### **Pre-Application Advice**

To demolish existing row of 4 shops with living accommodation in the roof space and replace them with a terrace of four two storey dwellings.

80-86 Elmer Road Middleton

TITLE PROPOSED TERRACE OF 4No. THREE BEDROOM DWELLINGS 80-86 ELMER ROAD.	
CLIENT FINEMOTT LIMITED	
SCALES 1:50	
DRAWING No. 2038/05	DATE MARCH 2015
Michael Hemmings BUILDING DESIGN 8 ALFOLD BUSINESS CENTRE LOXWOOD ROAD ALFOLD SURREY GU6 8HP Tel: Loxwood (01403) 752029

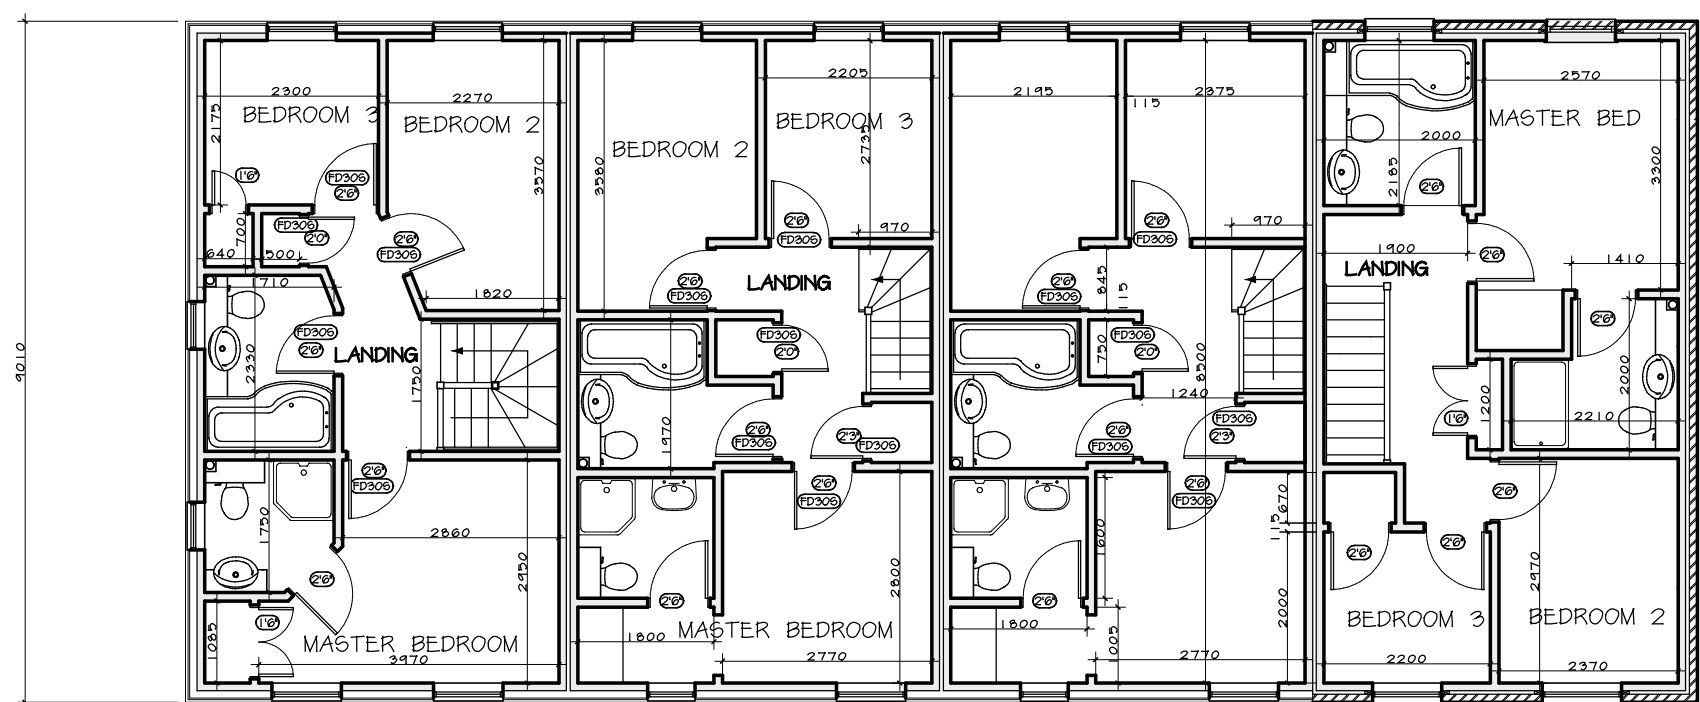
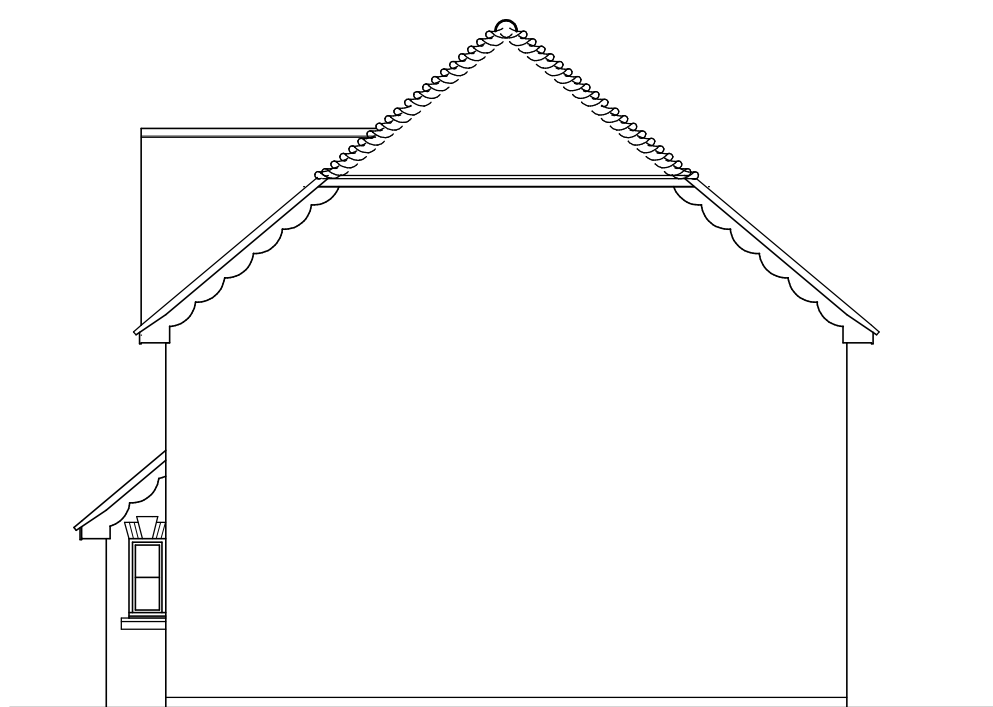
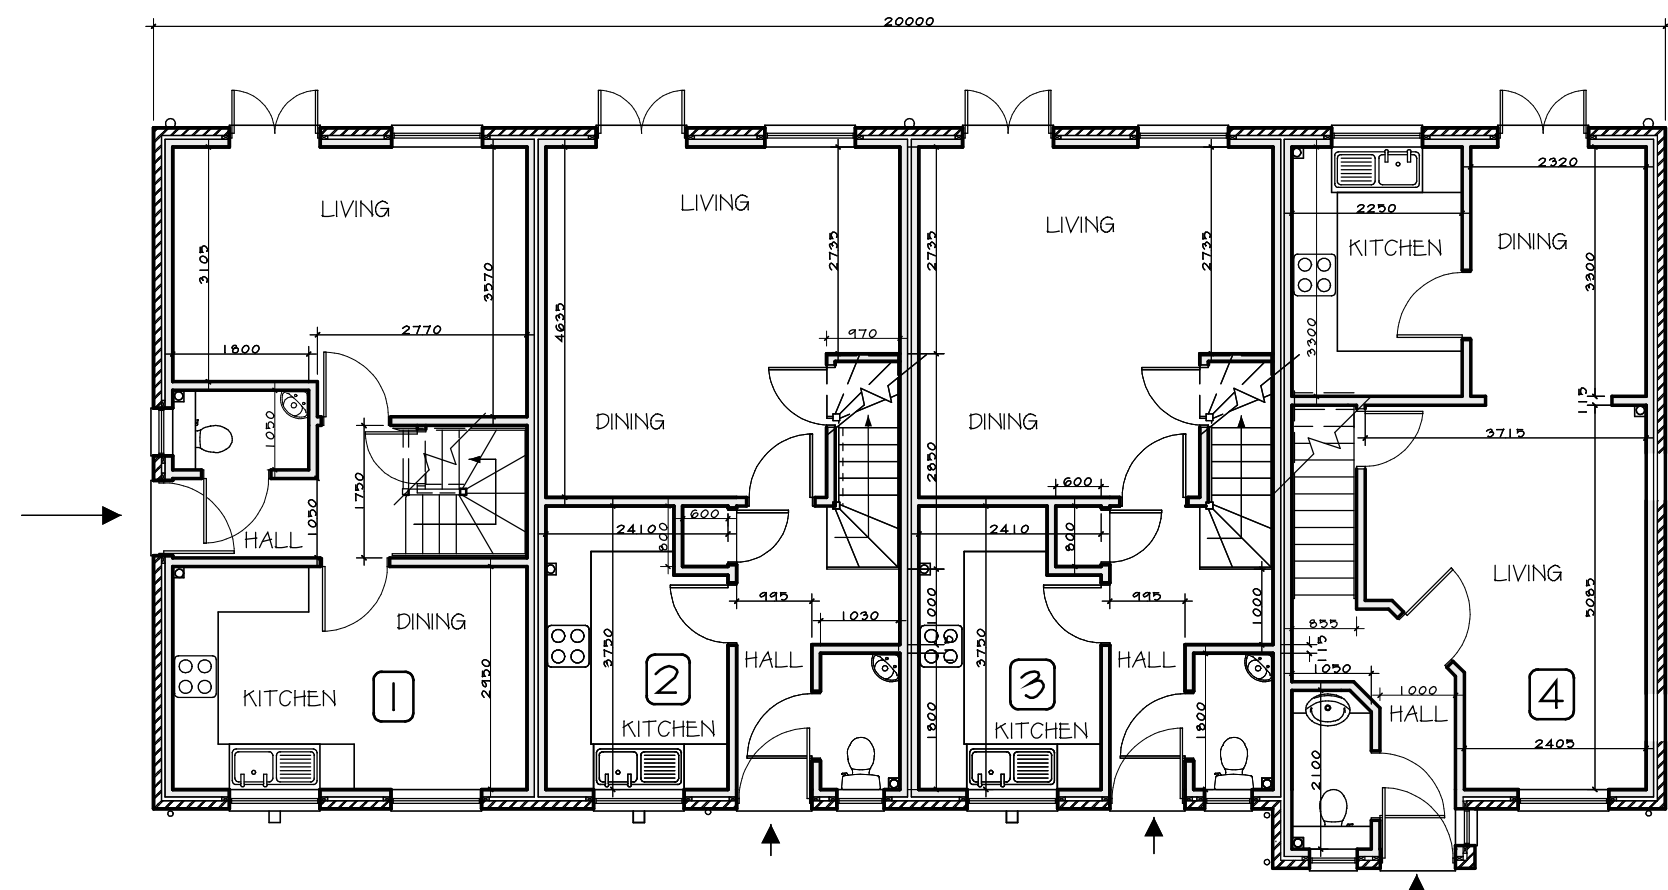
The proposed development is considered unacceptable by reason of conflict with policies and advice because the roof heights of the units would be significantly greater than adjoining development to the south and the proposal would therefore appear prominent and obtrusive in the street scene.

With regard to layout policy DDM2 sets out the minimum internal space standards for new dwellings to meet the changing needs of occupants and policy DDM3 sets out minimum private amenity space standards. New developments are required to meet the guidelines. The minimum Essential General Internal floor area for a 3 bedroom 4 person 2 storey house is 87 sq m. The proposed plots have an area of 77m<sup>2</sup>. None of the properties therefore meet these requirements. All plots have undersized second and third bedrooms and ground floor toilets. Policy DDM3 requires 3 bedroom semi detached developments to have a minimum rear garden size of 85 sq

metres. The largest garden is 60sqm, 2 are 50sqm and the smallest is 30sqm is significantly below this requirement. The proposal does not meet these standards and whilst refusal of the application solely on these grounds would be inappropriate given that the Plan has not yet been adopted it does indicate that the development is cramped and that the dwellings proposed are too large for the plots. The footprints, height and number of units are excessive.

Arun District local Plan Policy GEN7 indicates planning permission will only be granted for schemes displaying high quality design and layout. It further indicates development will be permitted if it takes into account impact on adjoining occupiers, land, use or property. In this case, it is considered that the proposed development would be unacceptable on the residential amenities of neighbouring properties because the height and proximity of the unit adjacent to 'Mayfield' the bungalow to the south would be overbearing. The bungalow has a side facing dormer window which will be adversely affected by a loss of outlook and light reduction given the roof height.

The proposal by virtue of its size, height and design does not relate sympathetically with the existing character and appearance of the area. Furthermore, the proposal by reason of its plot coverage and limited rear garden size would result in a cramped form of development which would not ensure a satisfactory environment for the occupants of the proposed properties, contrary to policy GEN7 of the Arun District Local Plan, policies DDM1, DDM2 and DDM3 of the Emerging Local Plan and the NPPF.

The proposal by reason of its height and proximity to the southern boundary would be unneighbourly on the adjoining residential dwelling in conflict with policy GEN7 of Arun District Local Plan and policy DDM1 of the Emerging Local Plan
